DECISION DELEGATED TO HEAD OF PLANNING

Application No:	H23-0356-23	Applicant:	Mr & Mrs S Pearce
Proposal:	Proposed extension to existing barn for hobby use		
Location:	115 Broadgate Whaplode Drove Spalding		
Terminal Date:	23rd June 2023

New Hedge Shown
OUTBUILDING AT 115 BROADGATE,
WHAPLODE DROVE, FOR MR & MRS PEARCE
EXISTING & PROPOSED SITE PLAN

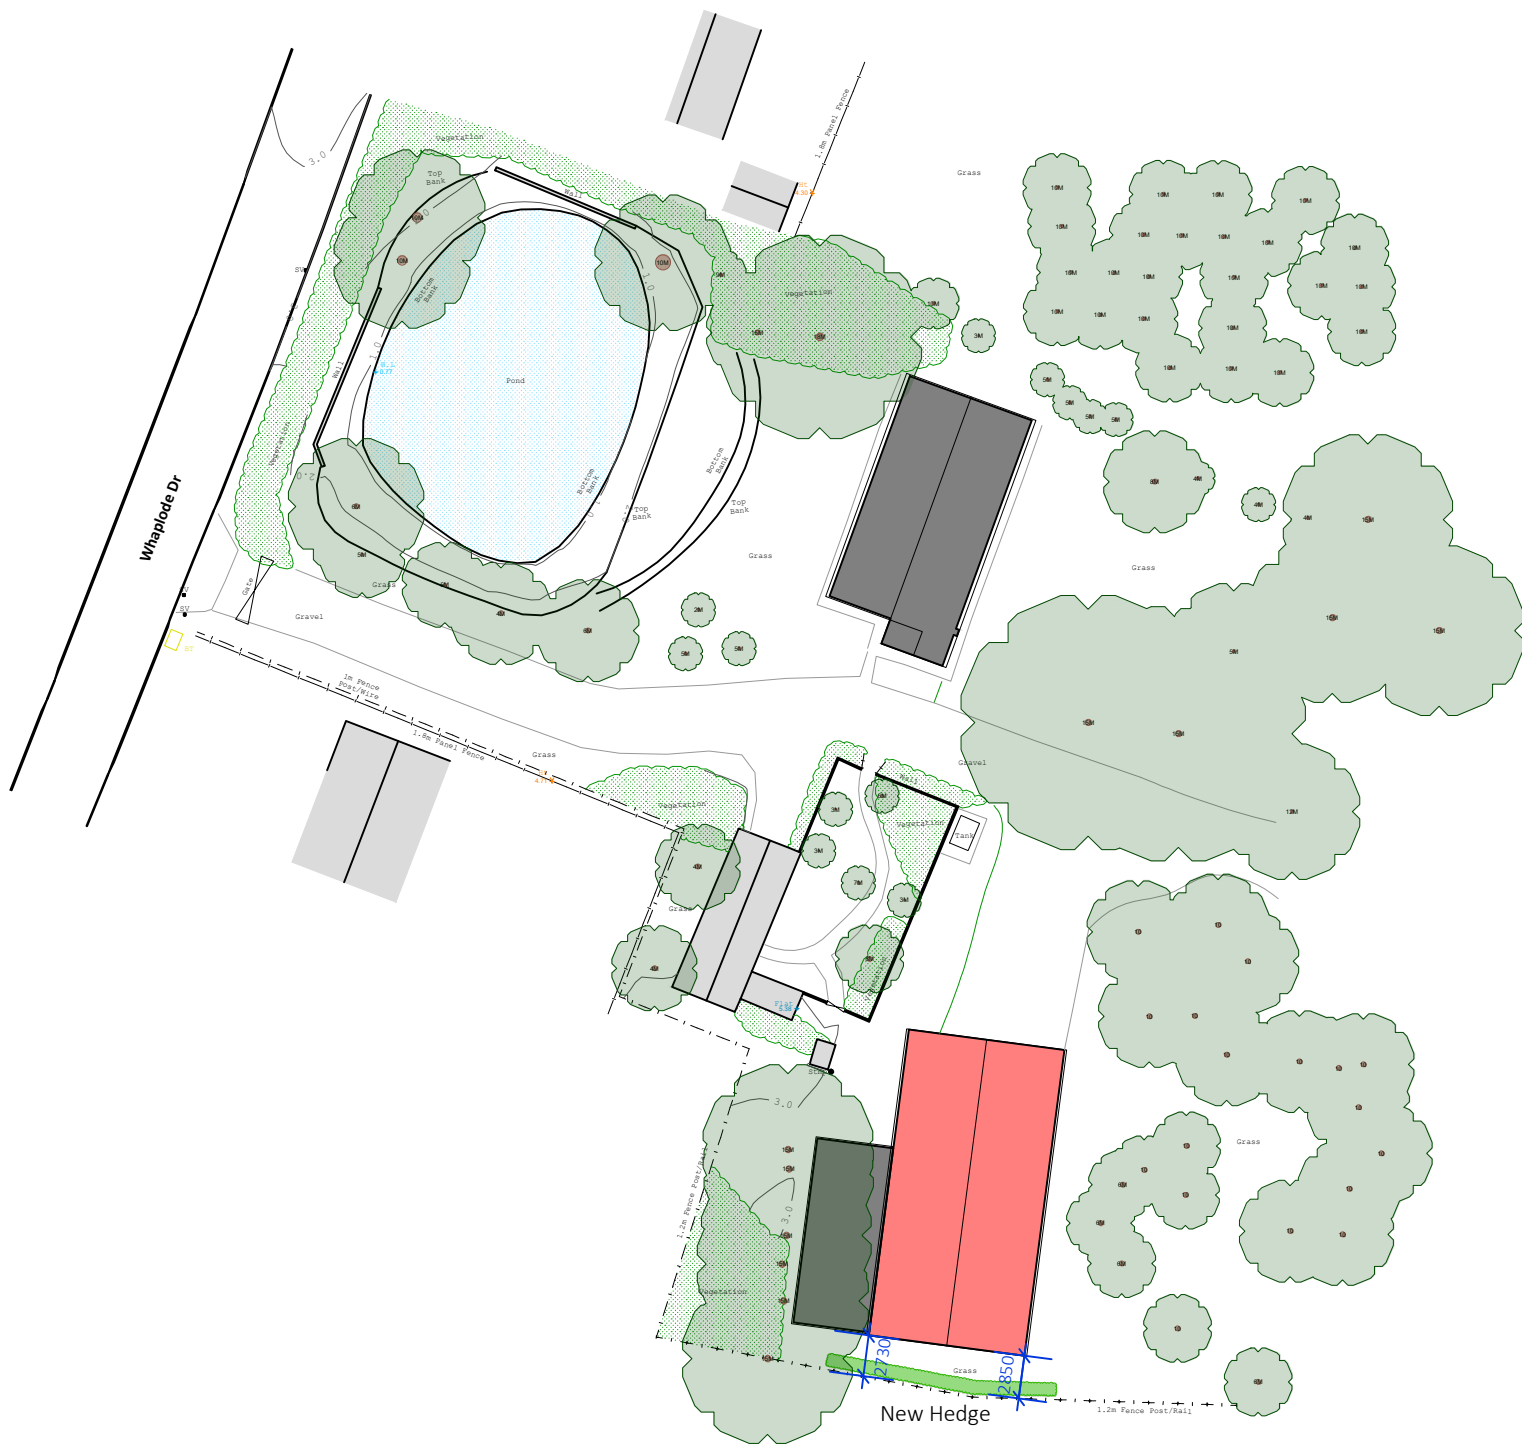
The proposed barn extension would measure 10 metres x 20 metres and stand at 6.8 metres in height. The proposed external material is olive green profiled steel cladding. The proposed size of the barn extension is not proportionate to the existing dwelling on the site and is too large in

footprint and height for an ancillary domestic outbuilding therefore it would dominate the site. Discussions were had with the applicant in regard to reducing the scale of the building, however, no revised plans have been forthcoming.

Whilst the proposal is acceptable on residential amenity grounds, however, the proposed barn extension would be disproportionate to the size of the existing dwelling on the site and its footprint and height would be too significant for an ancillary domestic outbuilding.
